PROJECT NAME: M40 J10

STATUTORY CONSULTATION PROCESS – SCHEDULE OF APPLICANT’S RESPONSES TO COMMENTS RECEIVED

DATE ISSUED: 21 MARCH 2022

COMMENTS RECEIVED FROM:	Berkshire, Buckinghamshire and Oxfordshire Wildlife Trust	FORMAT:	Online	DATE RECEIVED:	22/11/2021
SUBJECT:	Objection to 21/03267/OUT and 21/03268/OUT

Drawing Title: **PARAMETER PLAN 08
VEGETATION RETENTION
& REMOVAL**

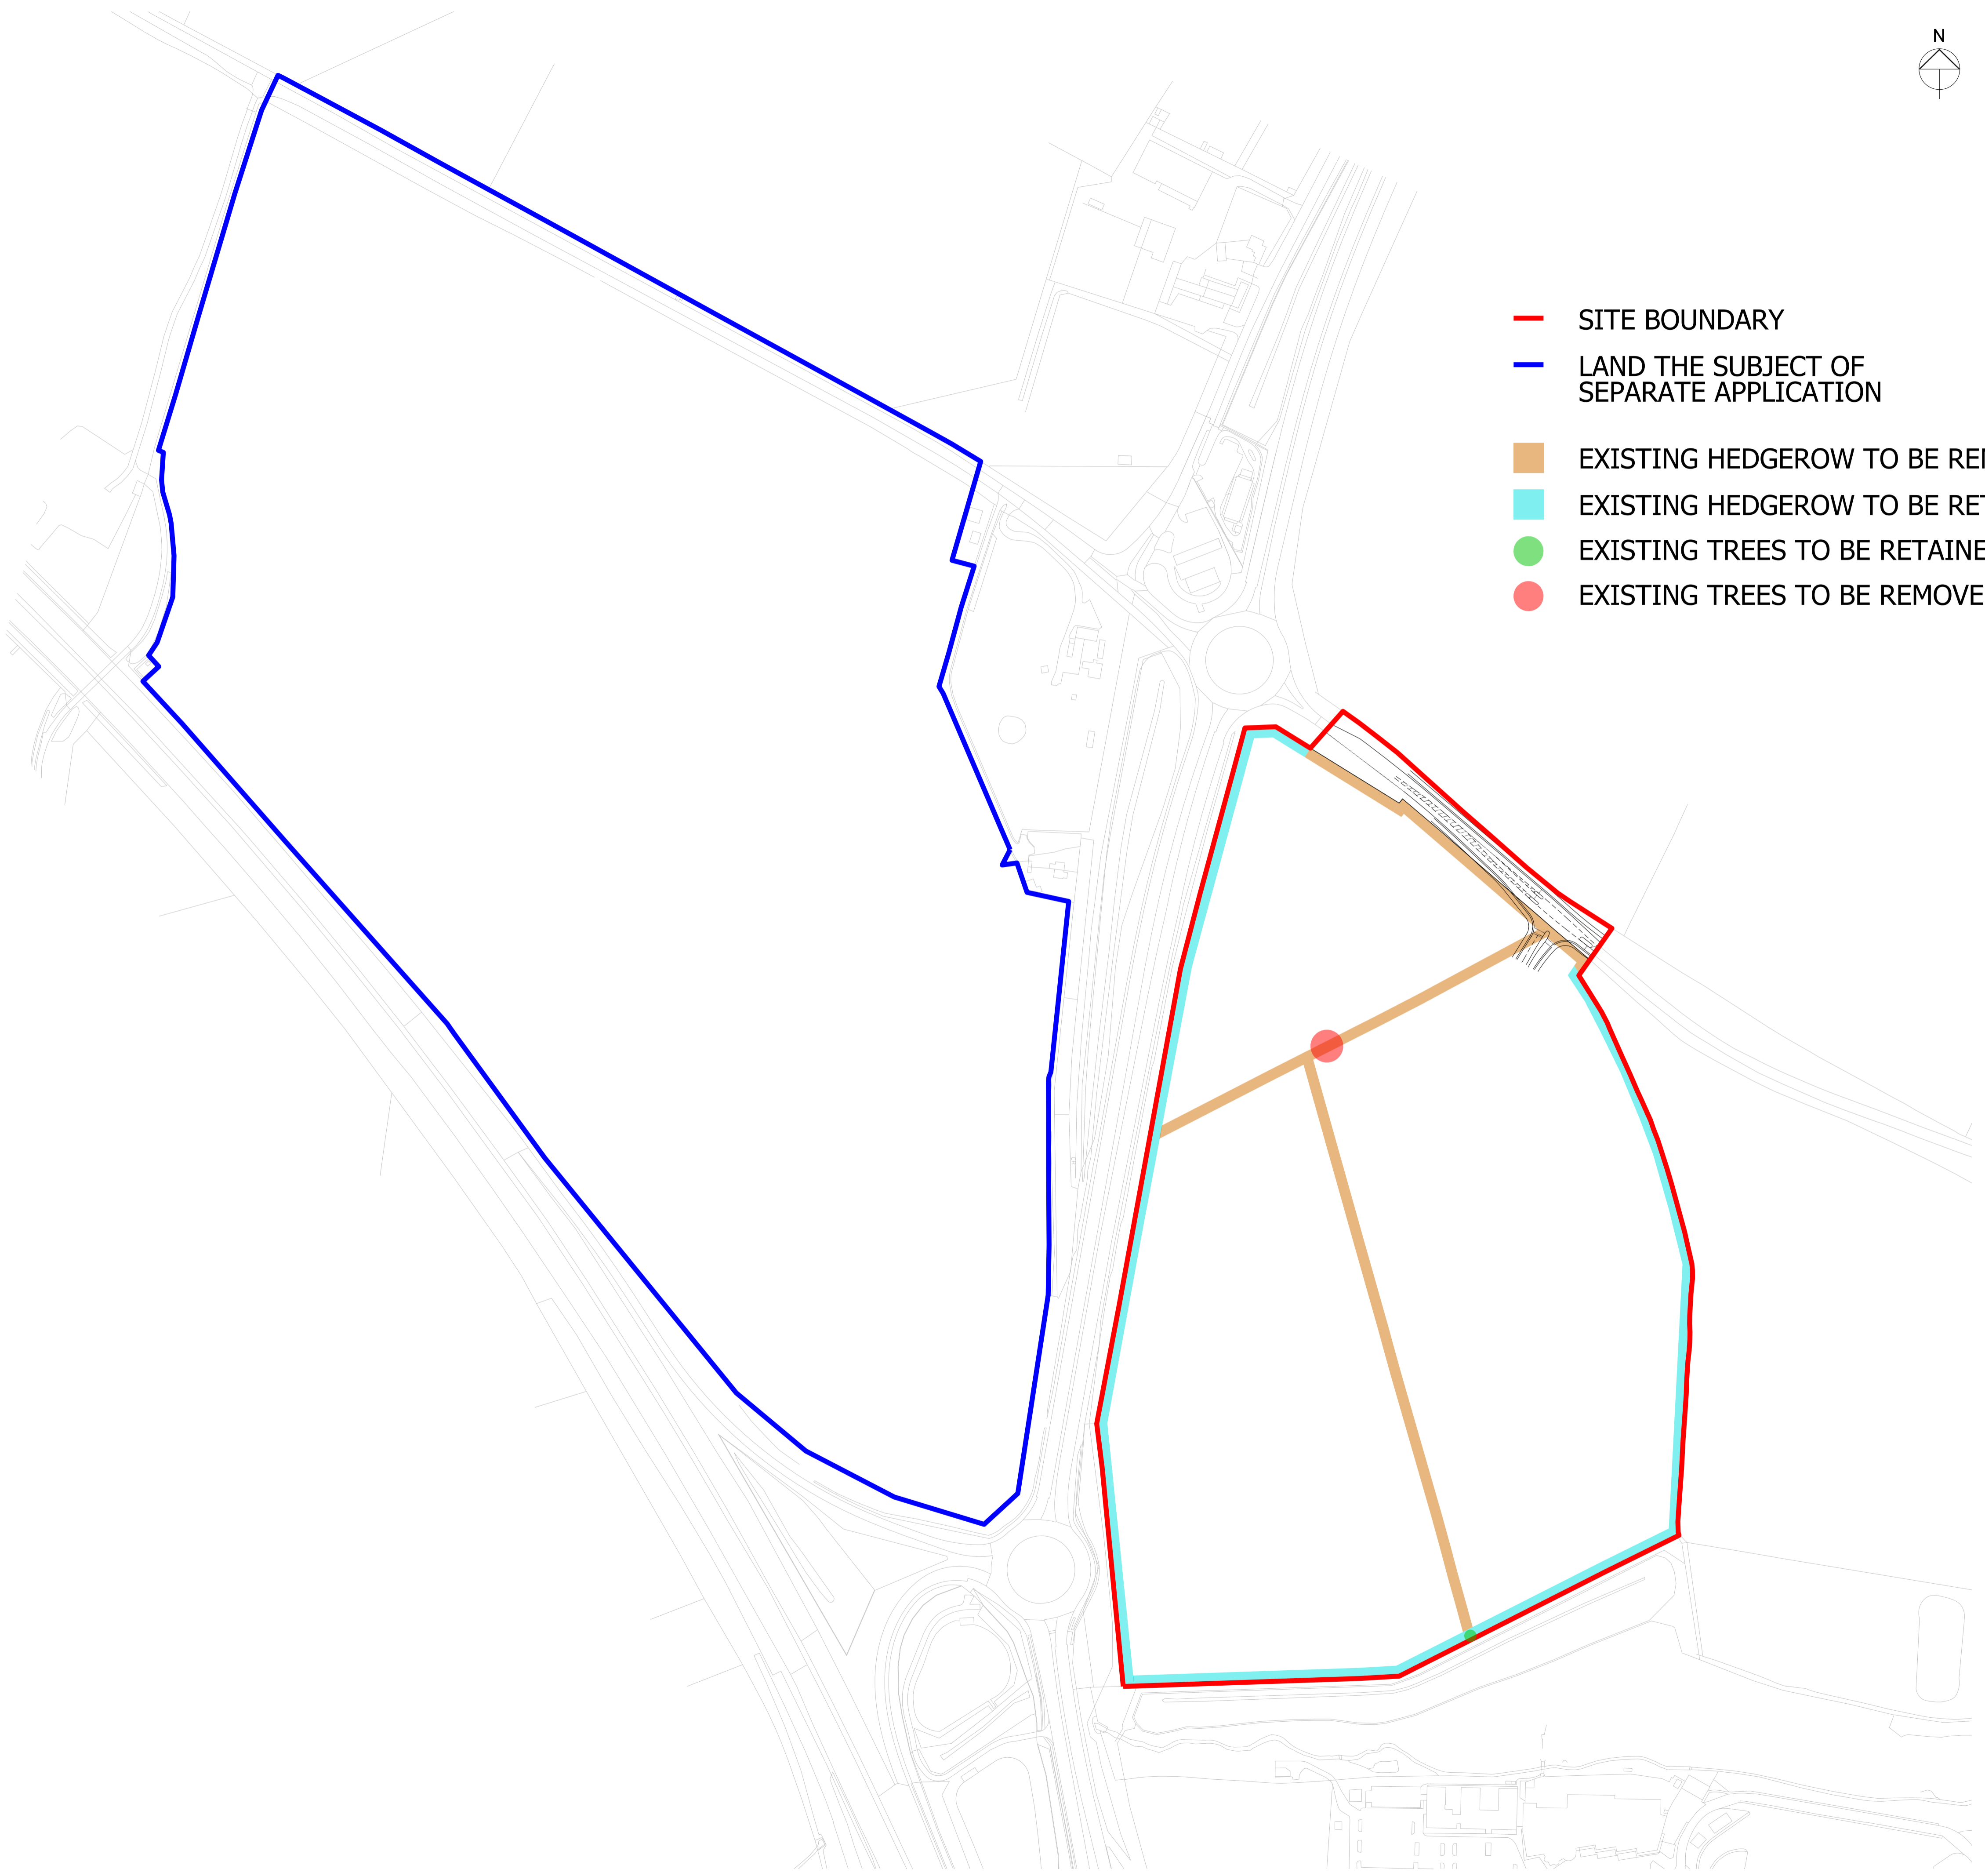
ID	ISSUE	COMMENT SUMMARY	RESPONSE
1.	Loss of hedgerow priority habitat	<p><i>“We are greatly concerned by the significant loss of wildlife habitat that this development would lead to with the current design.”</i></p> <p><i>...“We do not accept that the benefits of the development outweigh the harm it would cause to the site in relation to the loss of hedgerow and we do not accept that the mitigation proposed will achieve a net gain in biodiversity (see below). In addition, ecological networks provided by the hedgerows will be fragmented as a result of the development and for these reasons we believe the development would be contrary to Policy ESD 10 of the local plan which states that “ecological corridors should form an essential component of green infrastructure provision in association with new development to ensure habitat connectivity””</i></p>	<p>The hedgerows to be removed from the Site comprise defunct species-poor hedgerows which contain large gaps and are not well-connected to the boundary hedgerows or the wider landscape. Therefore, removal of these defunct, species-poor internal hedgerows is not anticipated to fragment ecological networks. The species-rich hedgerows around the boundaries of the Site are to be maintained except for two sections on the northern boundaries to facilitate access points. Replacement hedgerow planting will be completed within the Site, as close to these sections of hedgerow removal as possible, thereby maintaining habitat connectivity around the boundaries of the Site. Additional tree and shrub planting will further contribute to maintaining vegetated boundaries of the Site which will provide habitat connectivity to the wider landscape.</p> <p>It is acknowledged within the Biodiversity Environmental Statement Chapter that, in the absence of mitigation, a minor adverse effect is anticipated in relation on hedgerows which will be significant at the local level. When considering the mitigation and compensation measures to be applied, including the replacement planting on-Site and hedgerow creation at Piddington, it is concluded that the residual effect on hedgerows will be negligible.</p> <p>A draft biodiversity net gain assessment is presented within the Biodiversity Environmental Statement Chapter which demonstrates a 11.96% net gain in habitat units.</p> <p>An updated version of the metric has subsequently been prepared (to be issued separately in due course) based on detailed proposals for the off-site provision. This demonstrates a biodiversity net gain of 11.6% habitat units and 12% hedgerow units. The proposed off-site habitat enhancement includes the</p>

ID	ISSUE	COMMENT SUMMARY	RESPONSE
			<p>creation of neutral grassland (comprising grassland with a high proportion of flowering grasses) and hedgerows.</p> <p>It is therefore considered that the Development will comply with national and local policy of relevance including policy ESD 10 of the CDC local plan.</p>
